**WEST SUSSEX COUNTY COUNCIL
PLANNING SERVICES CONSULTATION**

SUBJECT: EP/24/18 - Approval of details reserved by condition imposed under EP/59/17/PL (APP/C3810/W/17/3183667) relating to condition 3-Construction Management Plan.

Tudor Lodge, 125A Sea Road, East Preston, West Sussex, BN16 1NX

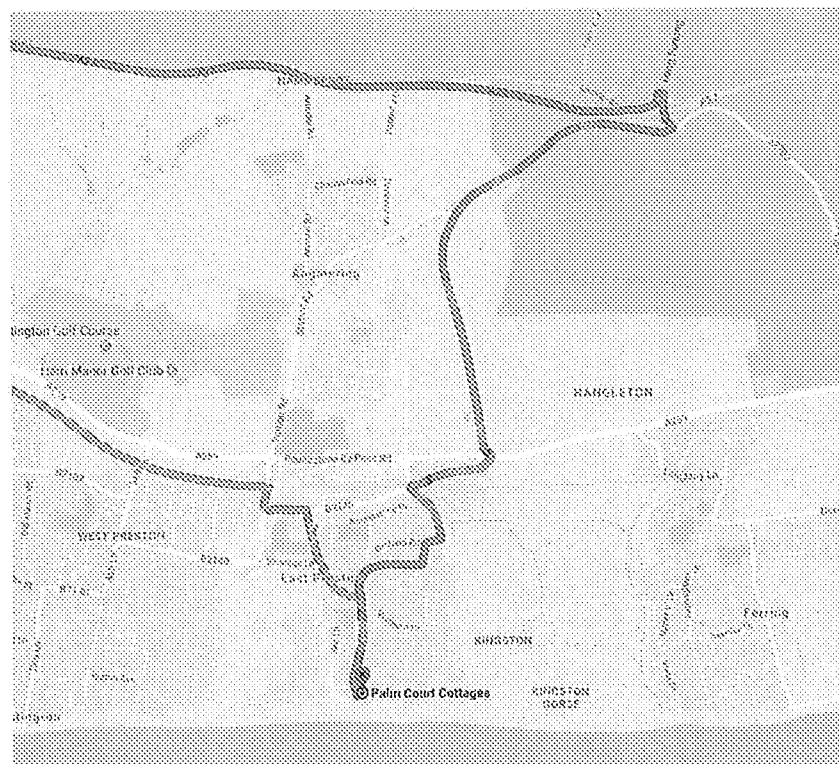
The Site Layout Plan indicates the access area and area for turning within South Strand. No reverse manoeuvres on to the public highway, Sea Road, are anticipated.

The CMP refers to wheel wash area indicated in orange and welfare units in blue however the document available online is not in colour. Please provide a coloured copy that also clearly marks out any proposed areas for material/plant storage, loading/unloading and the area for limited contractor parking within the site.
